Project Name: Loft Cados

Project Address: 30 Merrill Str.

Site Plan ID Number: # 2016-172

Project Name: Loft Condos  
Address: 30 Merrill Street  
Applicant: Banner Properties, LLC  
Planner: Nell Donaldson

1 FRONT (EAST) ELEVATION
SCALE: 1/4" = 1'-0"

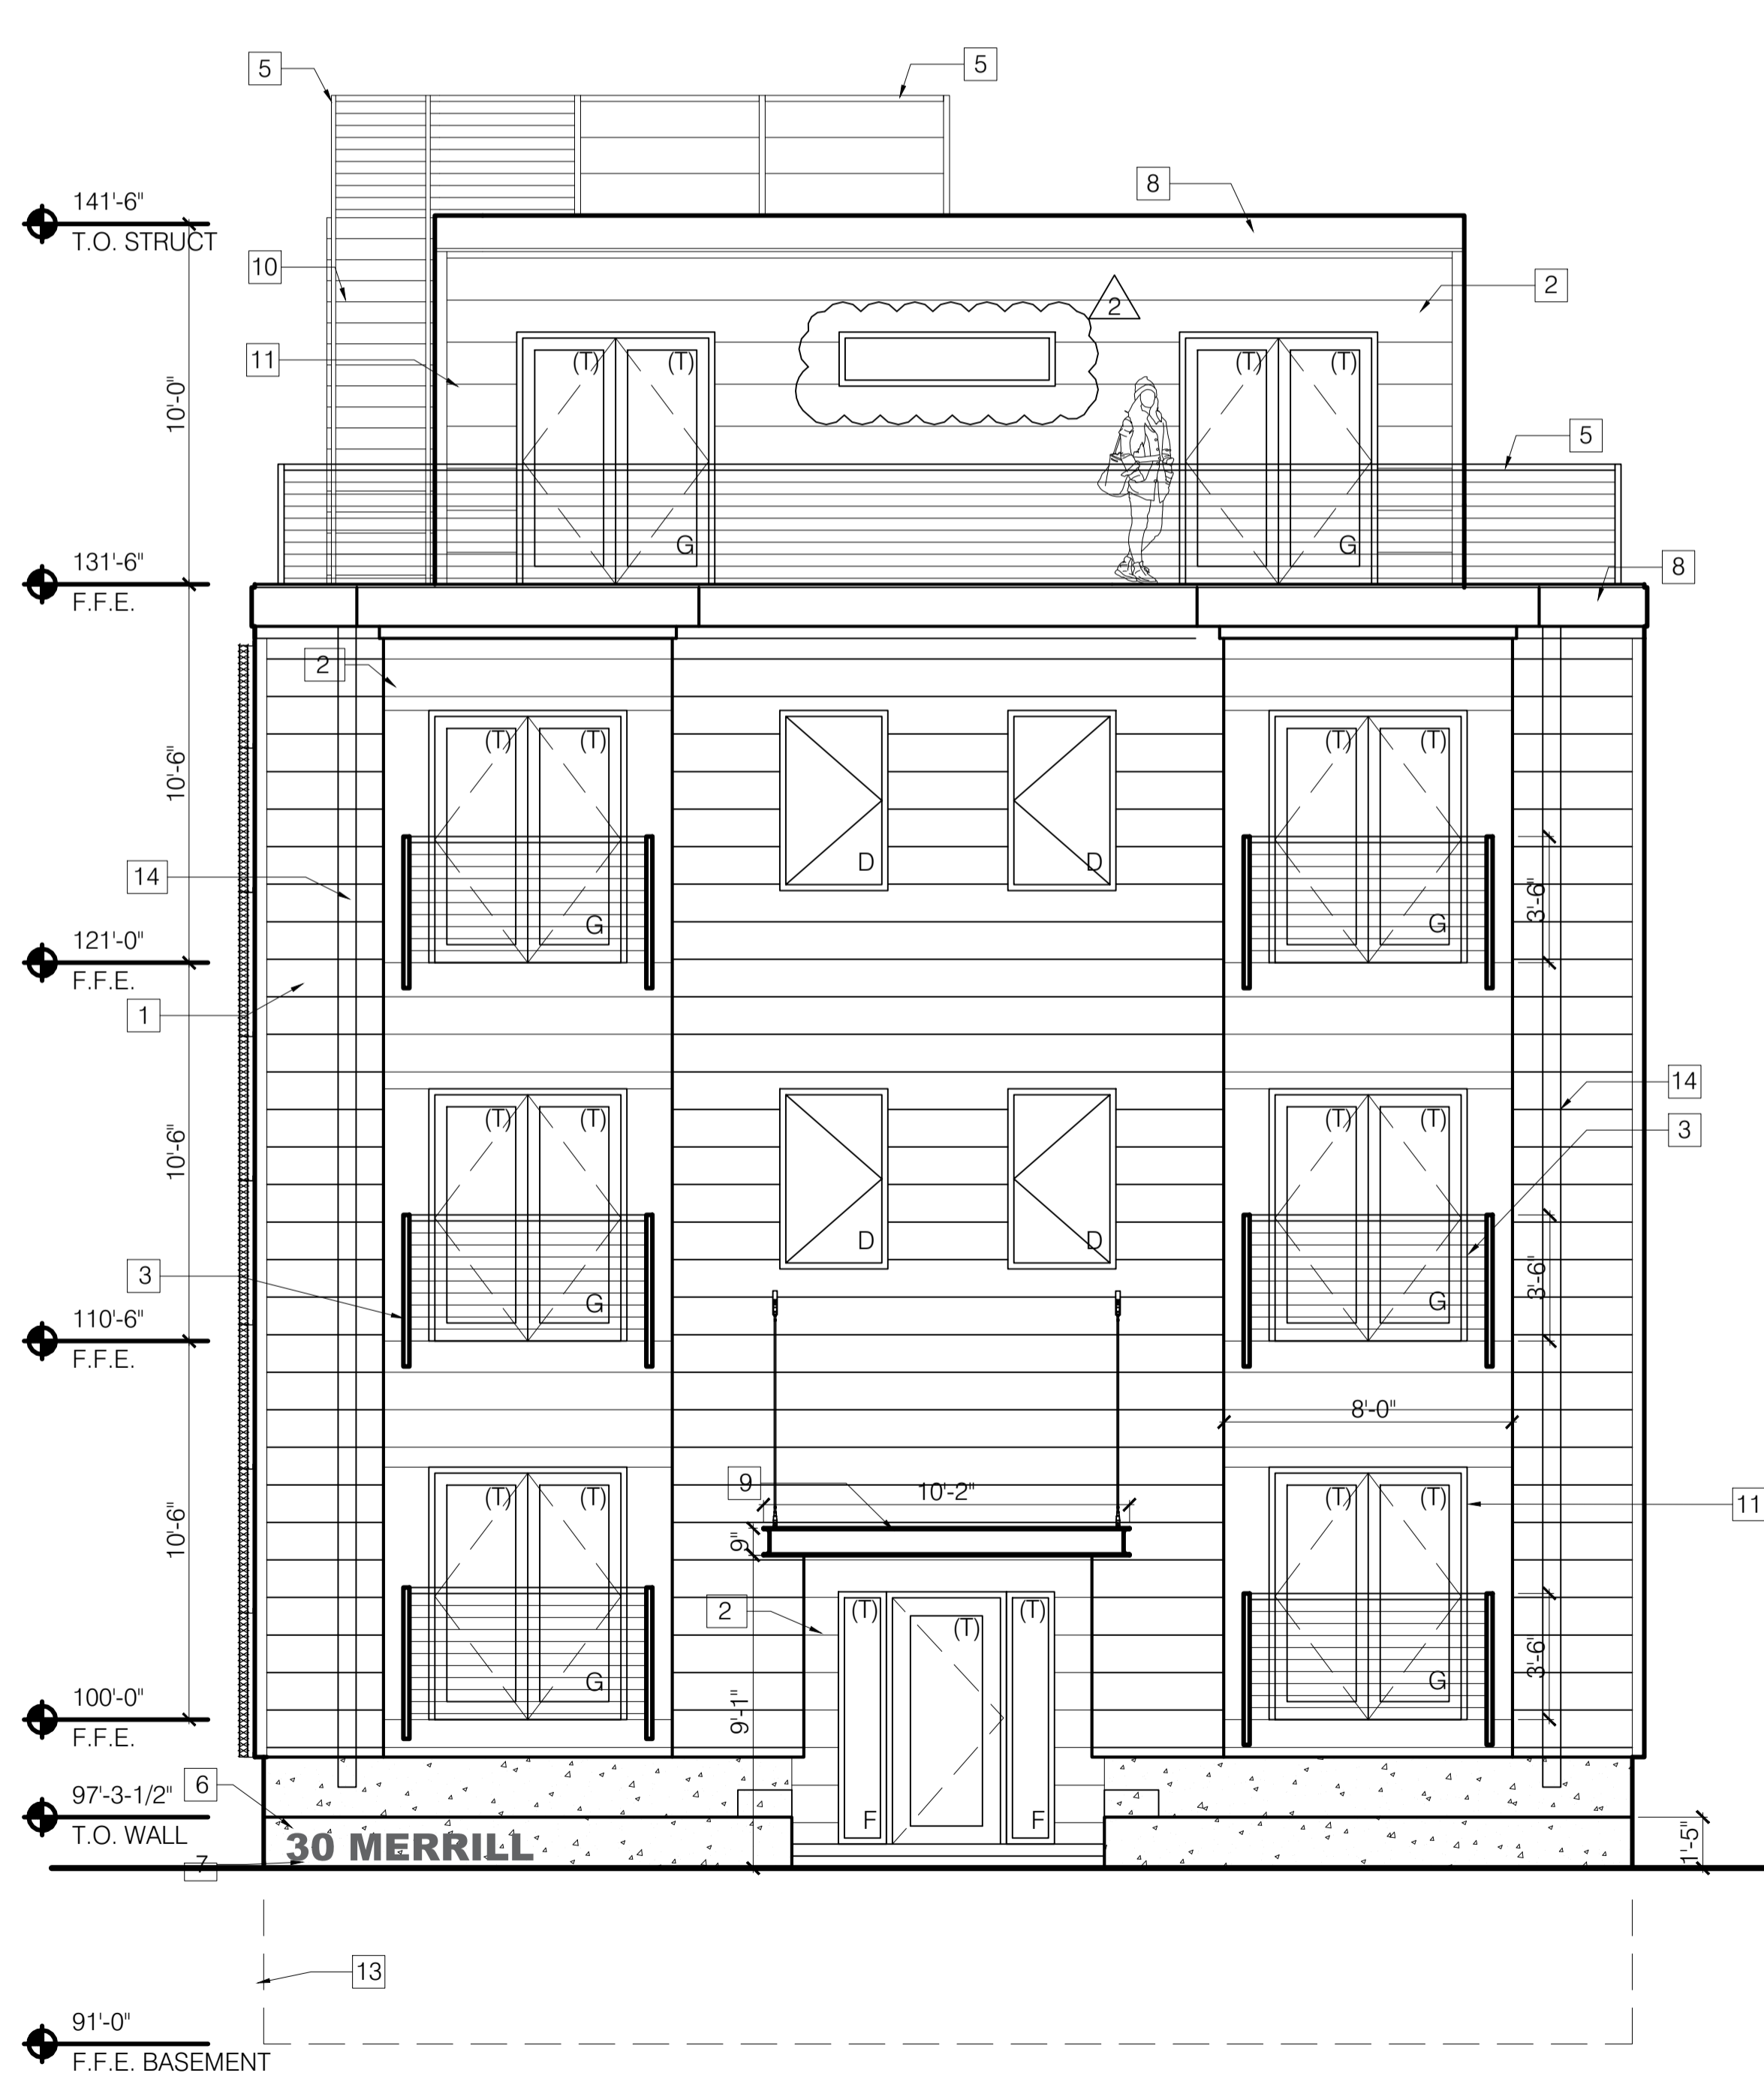
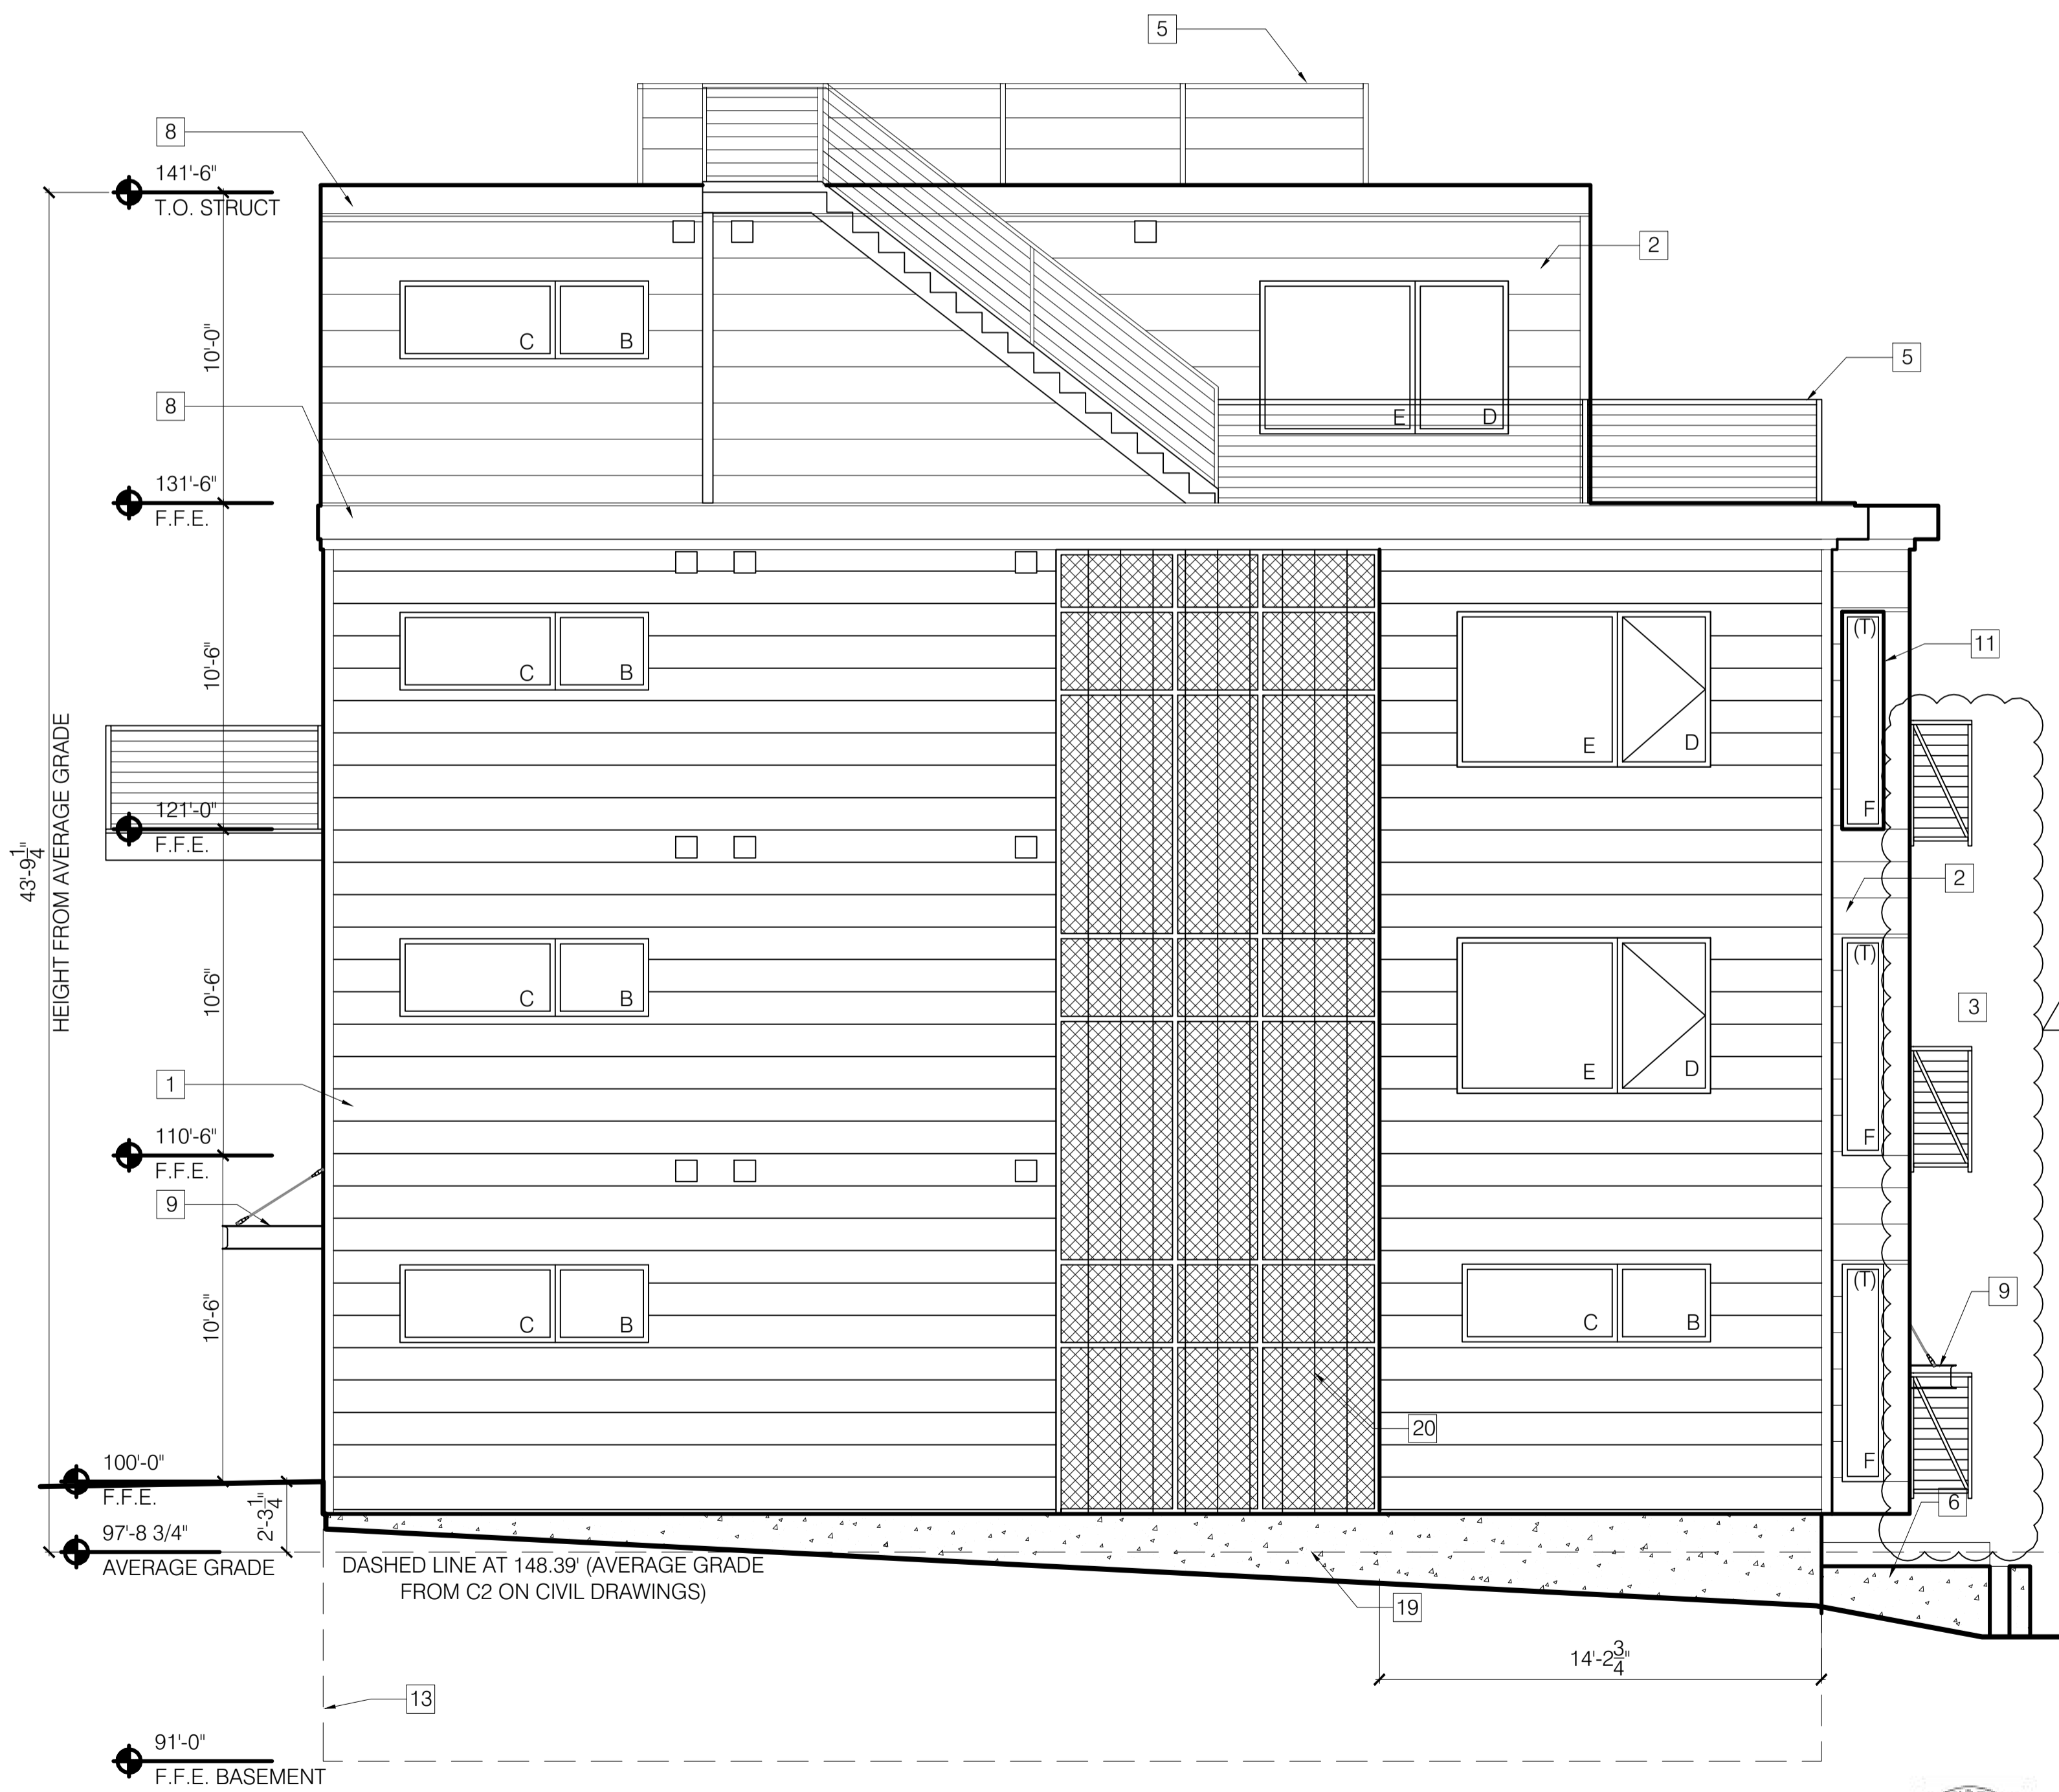
1. The applicant shall submit revised plans which:
  - a. Show the extent of sidewalk replacement on Merrill Street and include all relevant *Technical Manual* details;
  - b. Show a modified fence height at the front of the property to ensure safe sight distance; and
  - c. Show proposed steps and benches at the front entry as depicted in the architect's elevations for review and approval by the Department of Public Works;
  - d.

**DRIVEWAY APRON LAYOUT**  
NOT TO SCALE

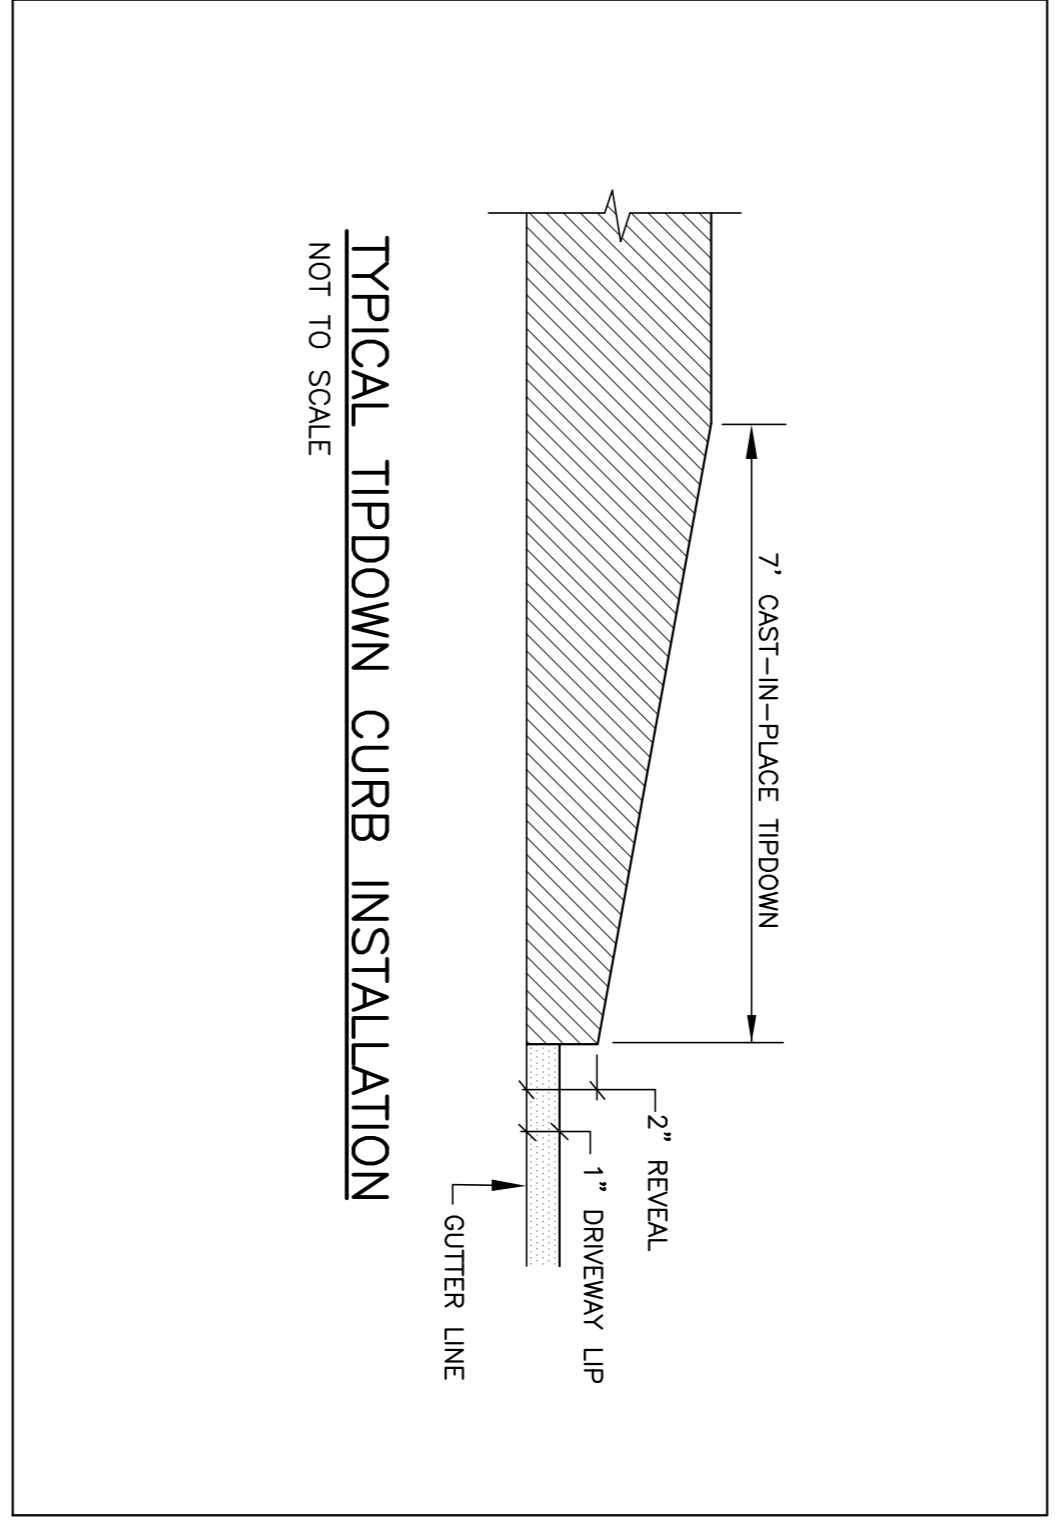
2. The applicant shall submit a final driveway apron detail meeting *Technical Manual* standards for review and approval by the Department of Public Works;

done  
12/31/16
